PRELODGE MENT ADVICE

Application No: PLM2019/0083

Property Address: 800 Pittwater Road DEE WHY, and
224 Headland Road DEE WHY

Proposal: Alterations and additions including change of use of premises for an educational establishment.

DRAWING TITLE
 STAGE 2 DROP-OFF & PICK-UP AREA
 B99 VEHICLE & TOYOTA COASTER
 ADDRESS
 No.800 Pittwater Road,
 Dee Why

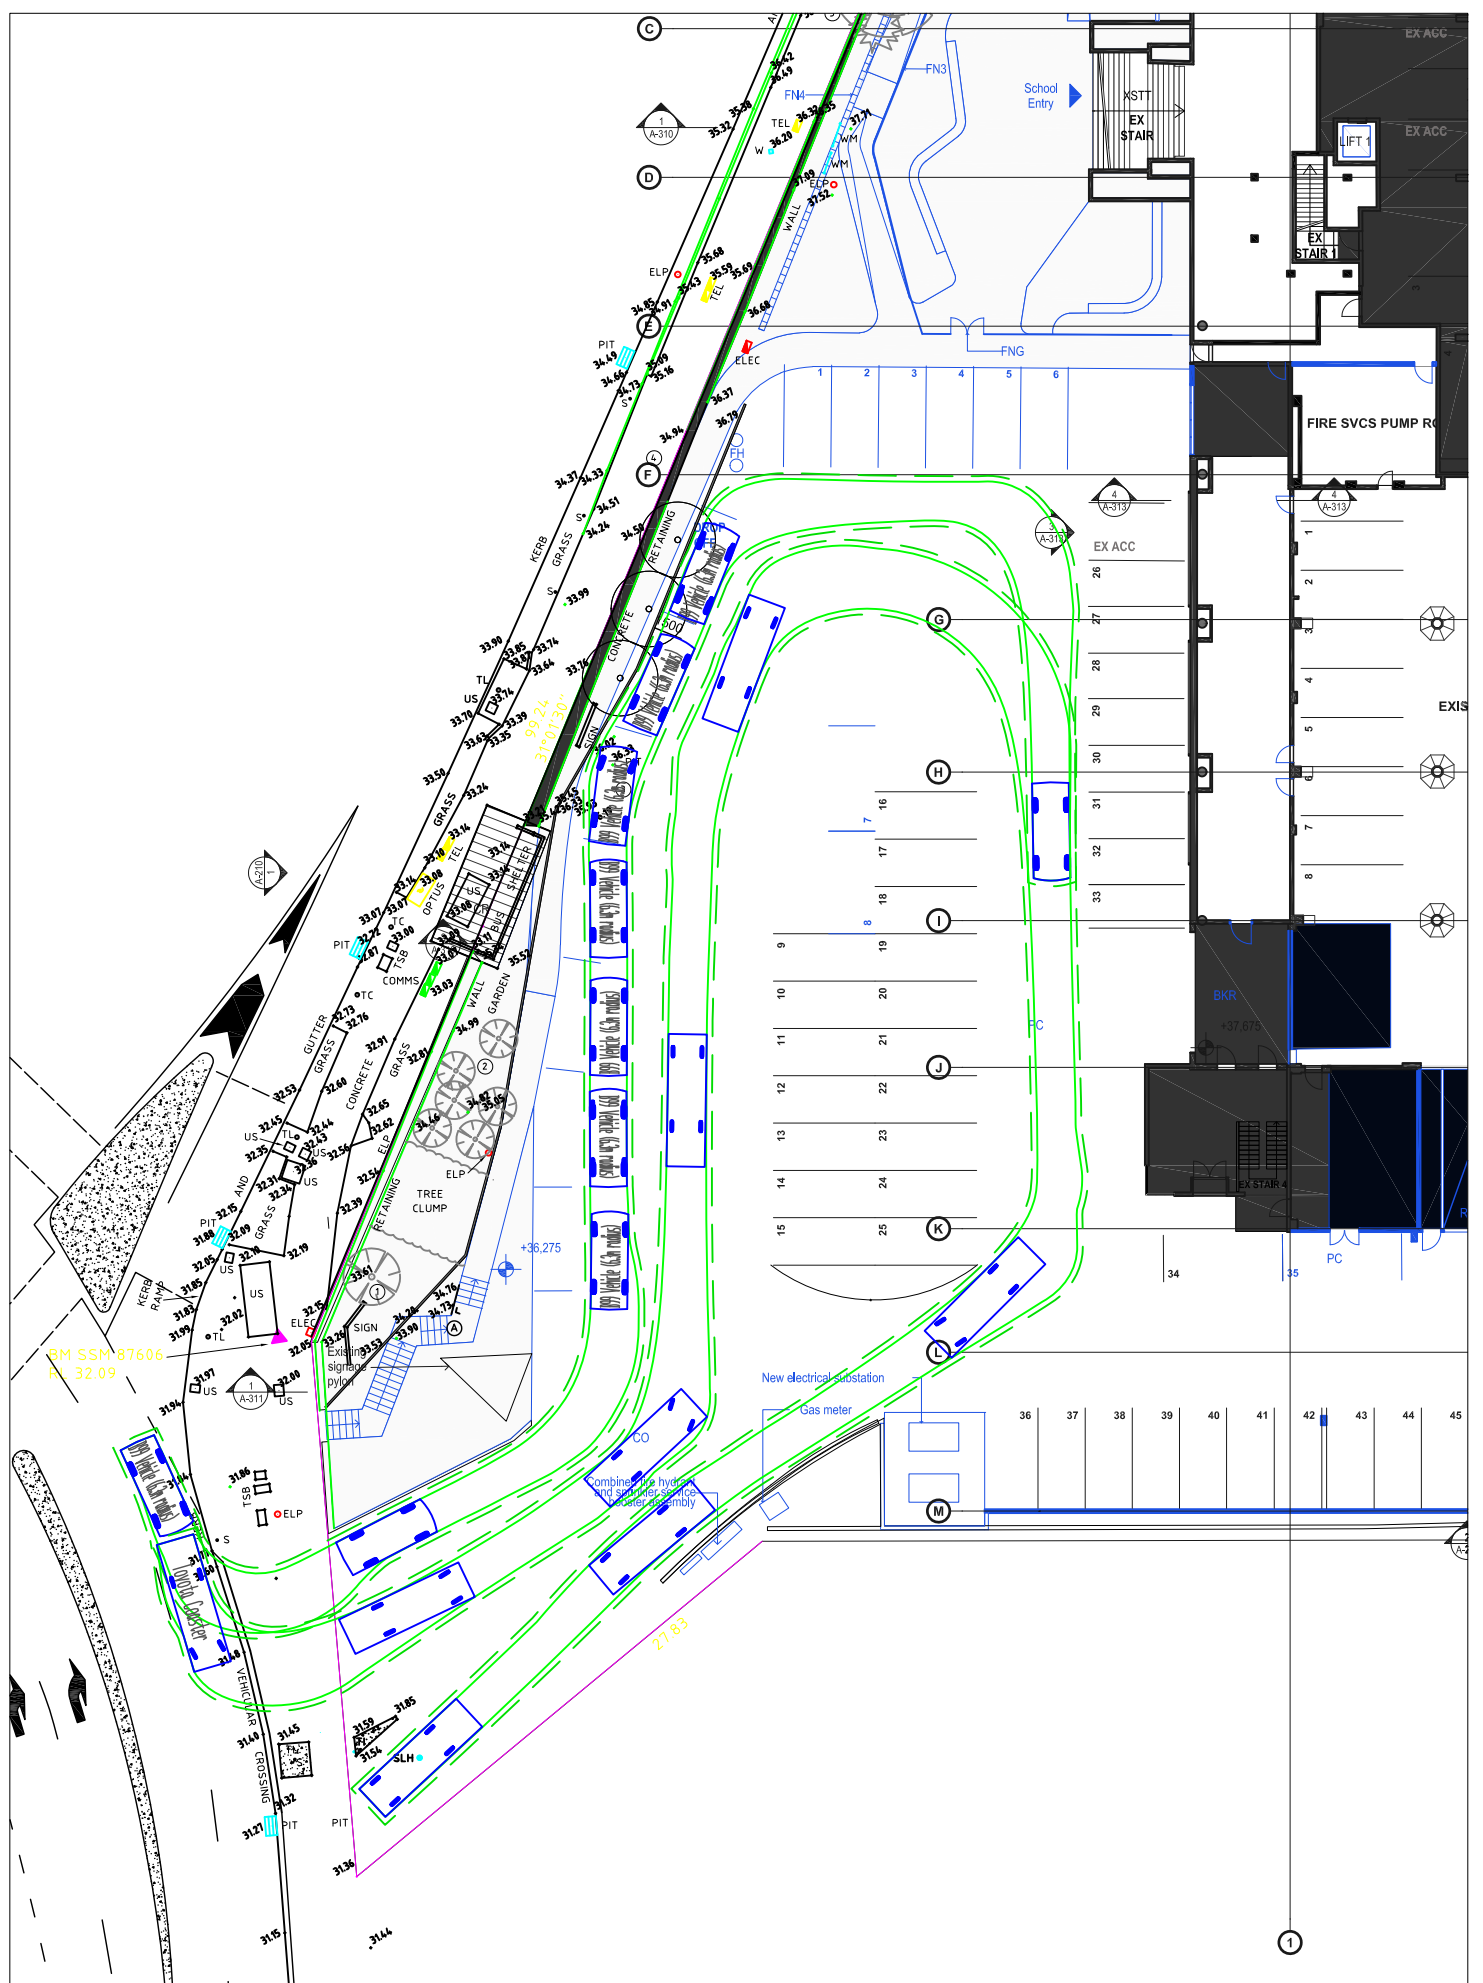
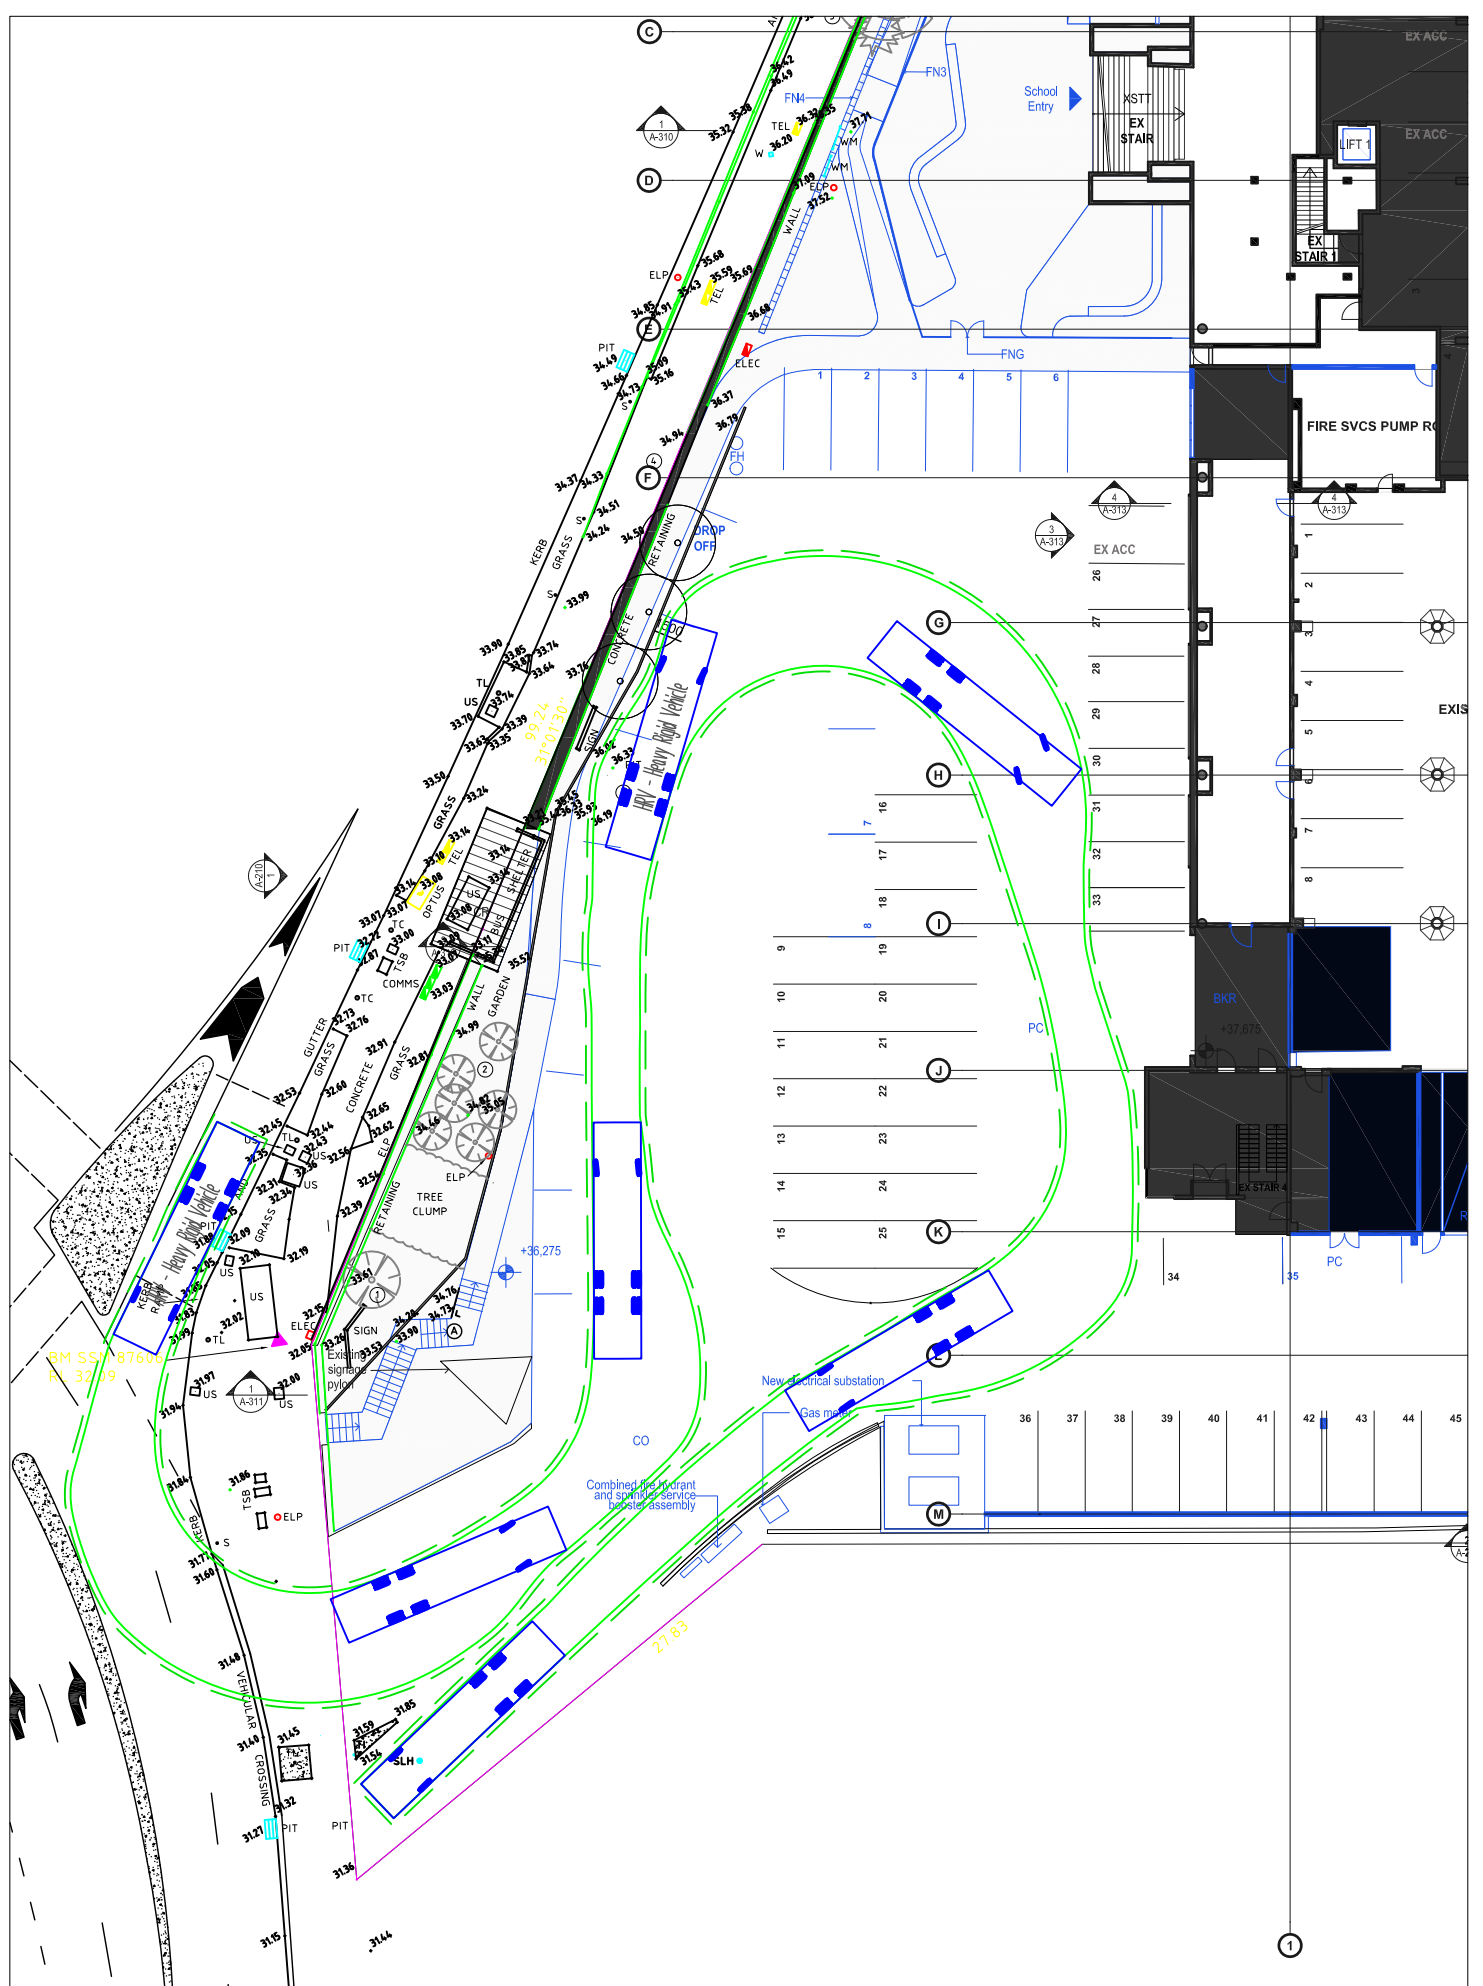
It is noted that the proposal includes changes to the forecourt of No.800 Pittwater Road to include a bus bay for rigid buses. Swept paths must comply with current standards and include details of marshalling areas and details of loading / unloading buses. No private vehicle collection of students is to occur from the street frontage of Pittwater Road or Harbord Road. The applicant needs to demonstrate no queuing will occur onto Harbord Road or Pittwater Road.

Measures to prevent north bound vehicles turning right into 800 Pittwater Road and vehicles exiting the site from turning right into Harbord Road should also be considered.
